**Canal &
River Trust**

Your Ref 2026/90254

Proposal: **ADDITIONAL INFORMATION:** Discharge of details reserved by conditions 3 (Phase II Intrusive Site Investigation Report), 7 (EV Charging Point), 8 (retaining structures foundations), 9 (CEMP), 10 (retaining walls and boundary treatments details), 11 (invasive species protocol), 12 (foul, surface water and land drainage scheme), 13 (1 in 100 year storm events), 15 (oil/petrol interceptor), and 17 (bat and bird box) on previous permission 2021/90605 for erection of an industrial building (B1(c) use)

Location: Land at, Vanguard Processing Equipment, Spa Fields Industrial Estate, Slaithwaite

DETAILED SECTION D-D - CALLOUT

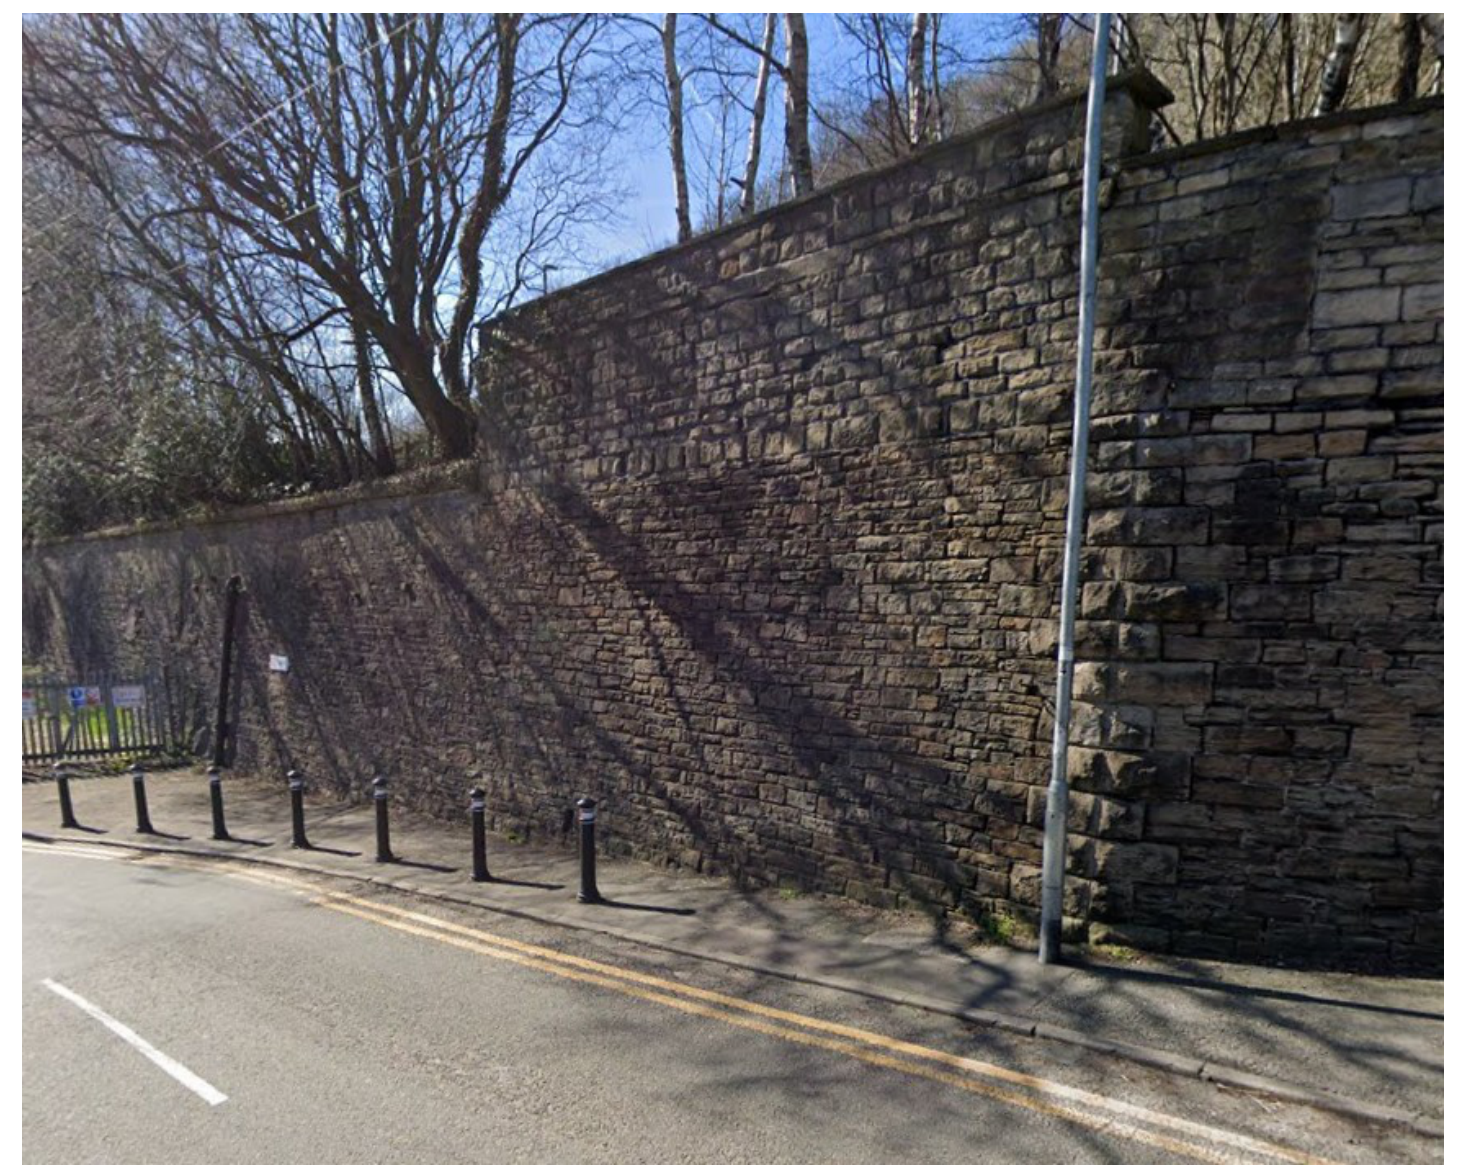
Our previous response dated 12th February 2026 did request further information with respect to Condition 8.

Having reviewed the latest information supplied, we are satisfied that the retaining wall detail and foundations relative to the canal should not significantly impact the canal structure. As a result, we are satisfied that appropriate detail has been received to allow for the discharge of this condition.
